CITY OF ALBUQUERQUE

**RE: Swinburne Dam Grade Control Structures
99999 Unser Blvd NW
Grading and Drainage Plan
Engineer's Stamp Date: 90% no stamp date
Hydrology File: A10D014**

Based upon the information provided in your submittal received 08/15/2025, the Grading & Drainage Plan **is not** approved for Grading Permit and Building Permit. The following comments need to be addressed for approval of the above referenced project:

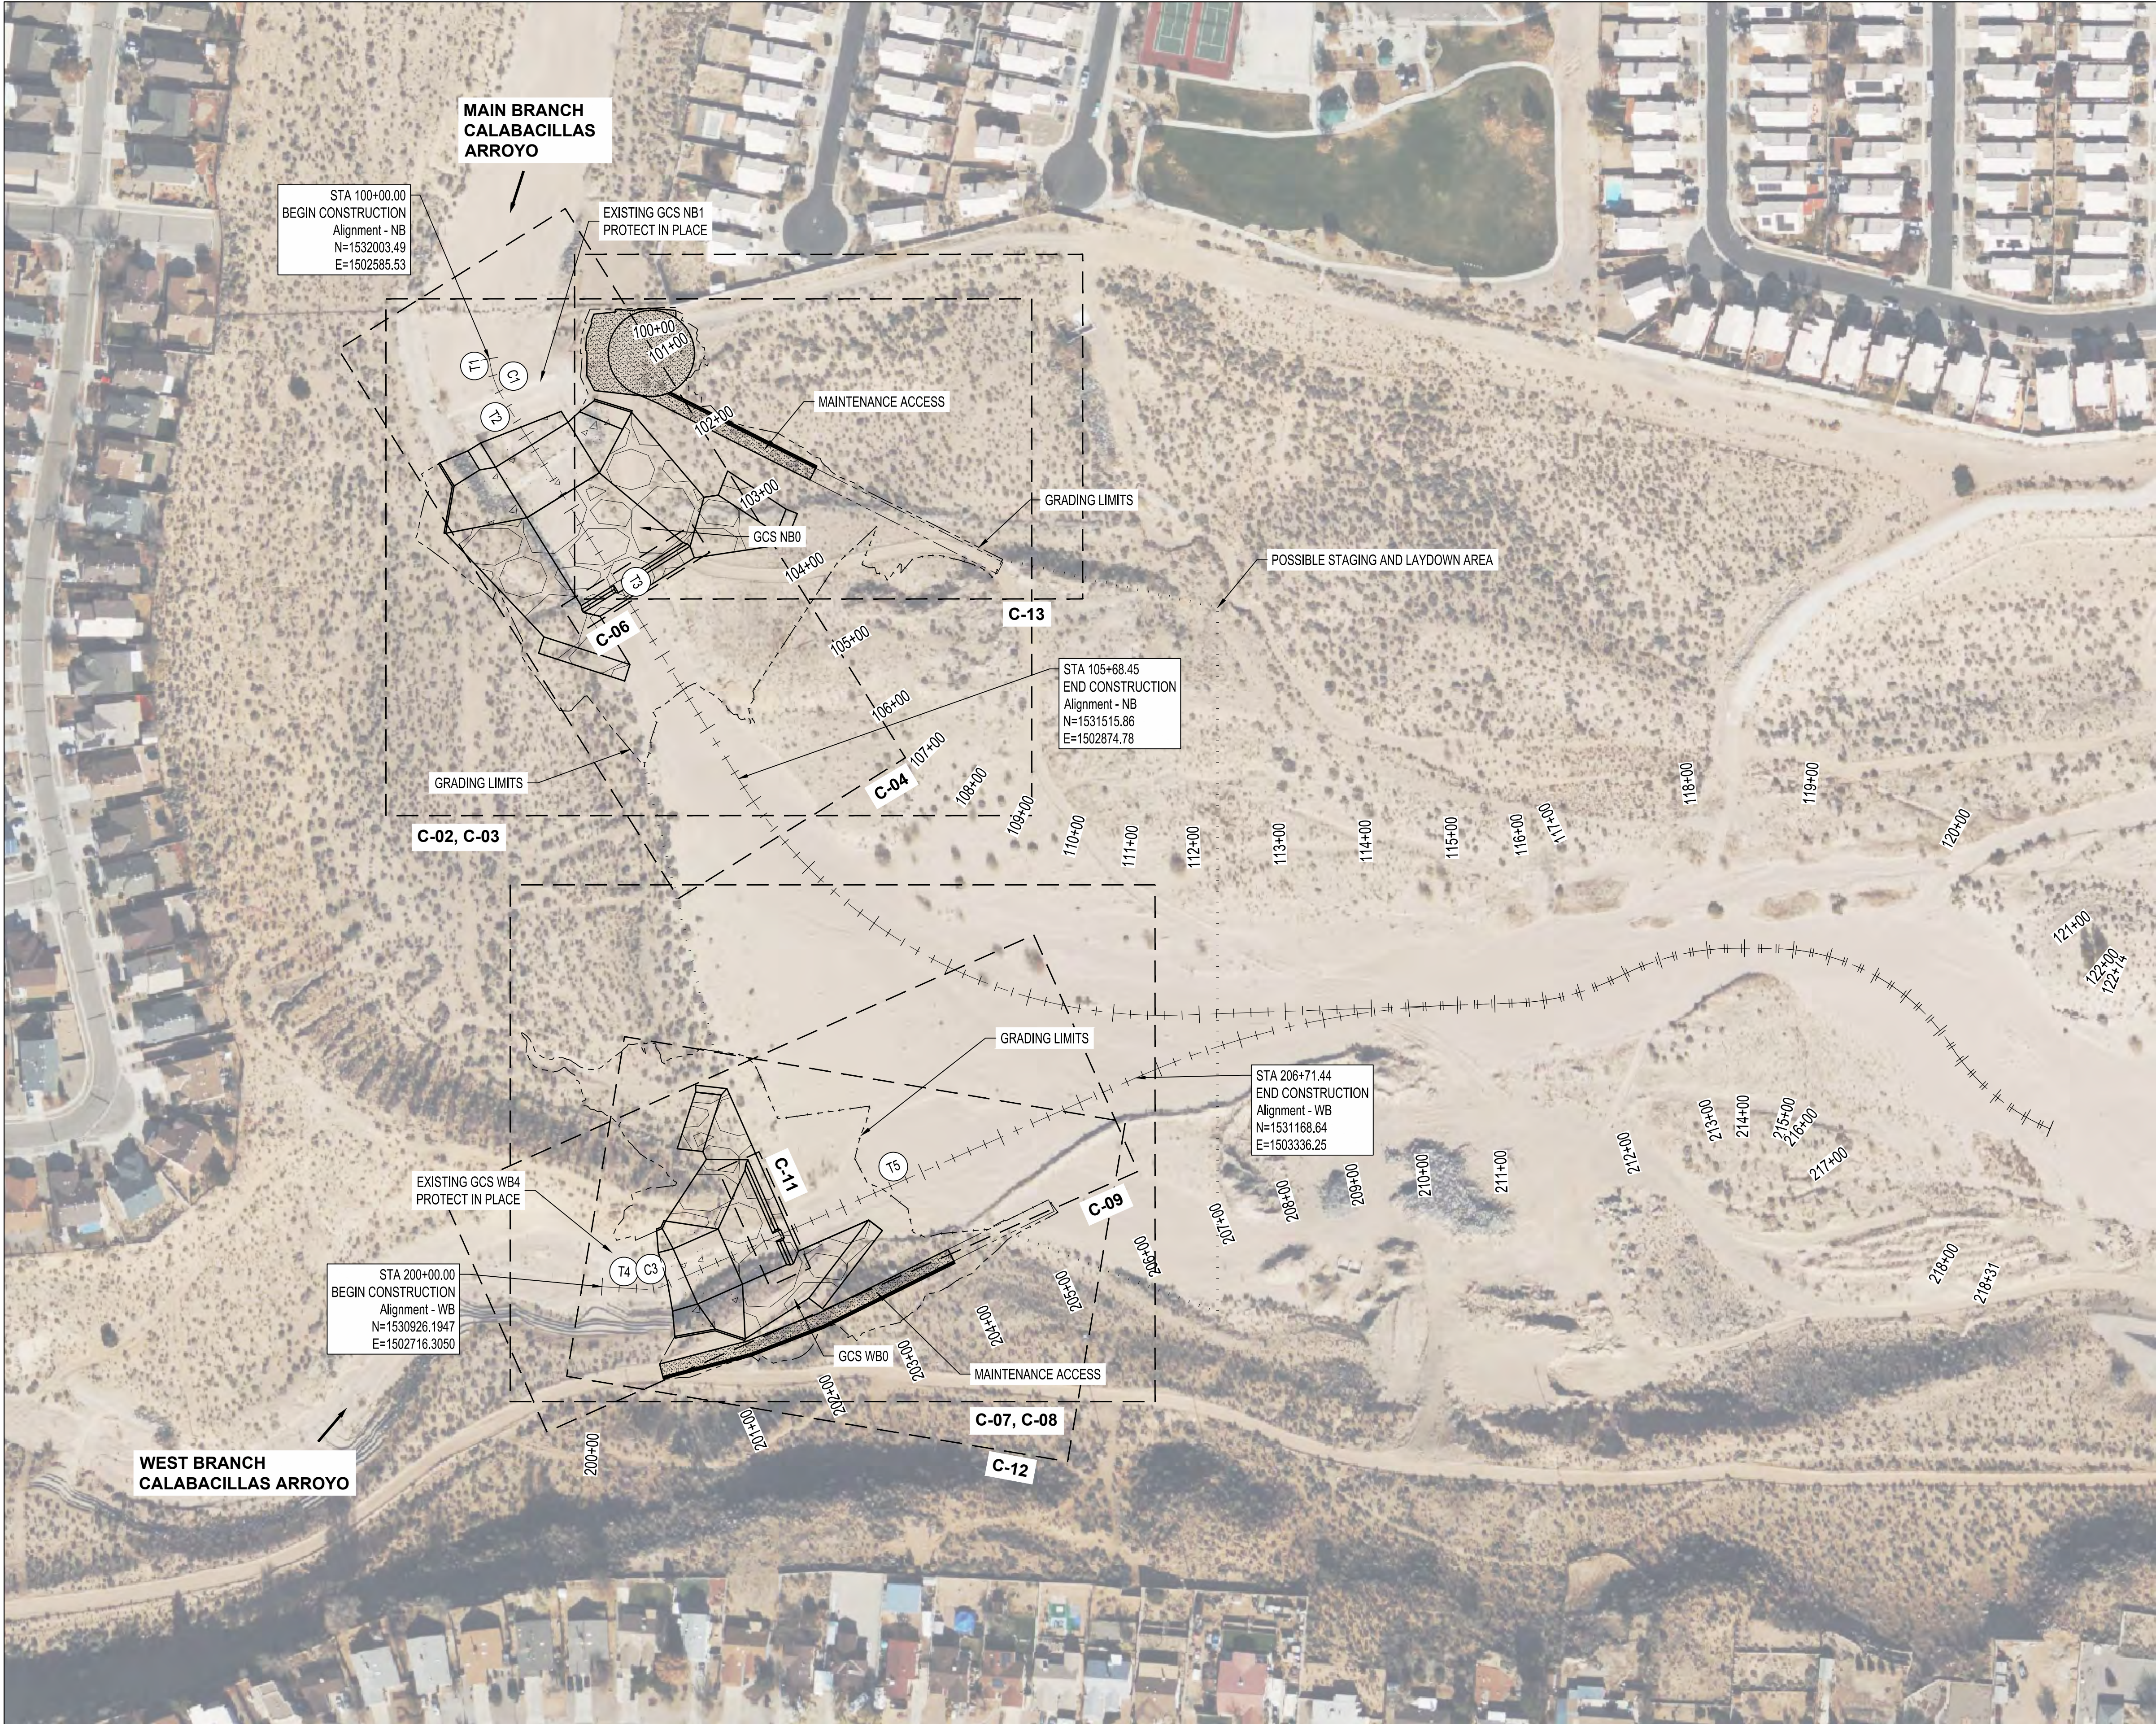
1. Per the DPM, the following must be on the Grading Plan. Please note the Grading Plan must be a stand-alone construction document.

- a. Please provide a licensed New Mexico civil engineer's stamp with a signature and date.
- b. Please provide the FIRM Map and flood plain note with effective date.
